Recommendation Report for Planning Permission for Works or Extension to a Dwelling

REF NO: R/229/19/HH

LOCATION: 15 Drewetts Close
Rustington
BN16 3TL

PROPOSAL: Single storey rear extension

PROPOSED GROUND FLOOR

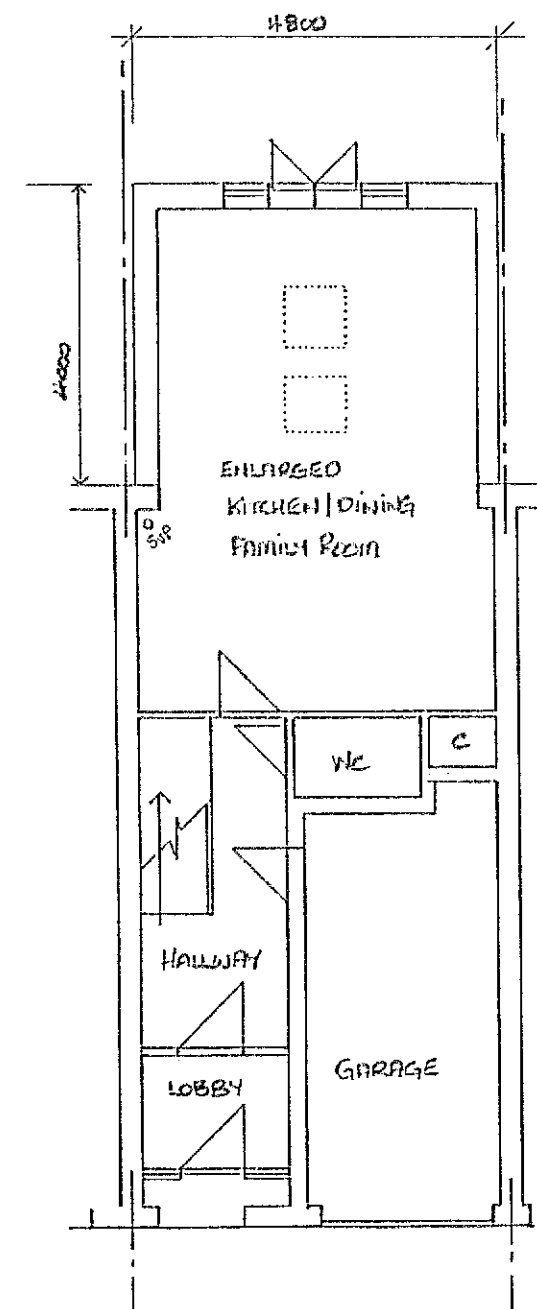
The applicant seeks planning permission for the construction of a rear extension to the established dwelling. The proposed rear extension will measure approximately 4.8m wide, 4m in depth and be built to the proposed height at top of lean to of 3.5m and eaves measuring 2.6m.

The proposed extension given its location will not be visible from the street scene. It will therefore not have a detrimental impact on the character of the host dwelling or the street scene.

The proposed extension is considered to appear subservient to the host dwelling and would not result in any adverse impact on the spatial pattern or character of the area and would therefore accord with the policies D DM1 and D DM4 of the Arun Local Plan.

PROPOSED REAR ELEVATION

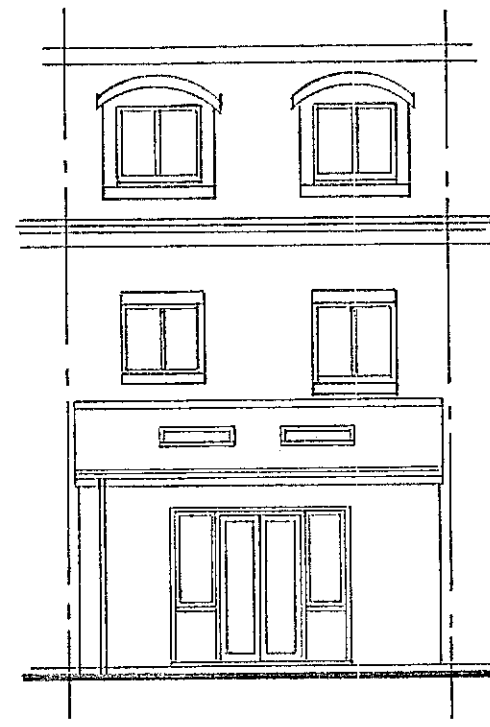
The proposed rear extension will be located 11m from the northern boundary which affronts the railway line and will run the width of the majority of the current garden. On the northern elevation there is 1 No. proposed set of doors to the rear that are to be the same style as the existing. The proposal includes two roof lights, these are not considered to cause any overlooking by virtue of their location given the proposal looks over the railway line therefore it has no impact on neighbouring amenities.

Given the design and location of the extension it is not considered to give rise to adverse impacts in terms of overlooking, overshadowing and overbearing and is therefore deemed to accord with D DM1 and D DM4 of the Arun Local Plan.

PROPOSED SIDE ELEVATIONS (FENCE SHOWN DOTTED FOR CLARITY)

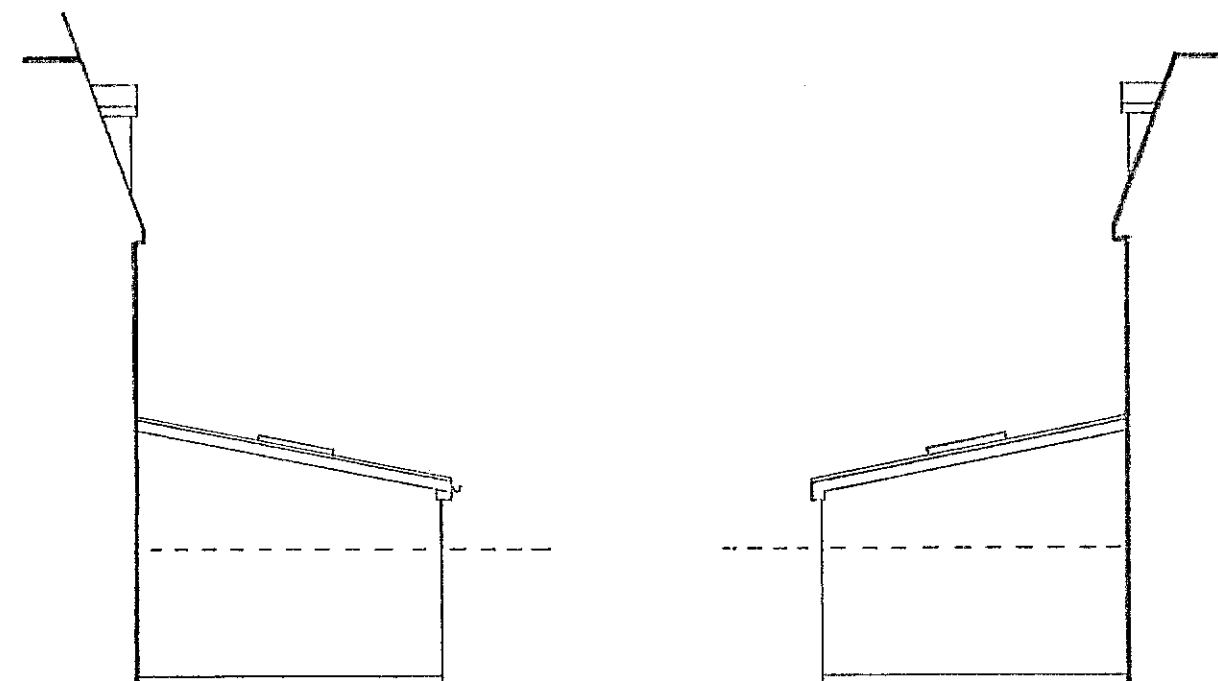
The 45 degree rule does impact this application as all development would be within the view of the window on the neighbouring properties northern elevations. The impact on residential amenities is acceptable given that the extension is single story and has a sloping roof. Therefore, it does not appear to be overbearing on the property and does not significantly impact the view from the adjoining property, therefore it is not a cause for refusal.
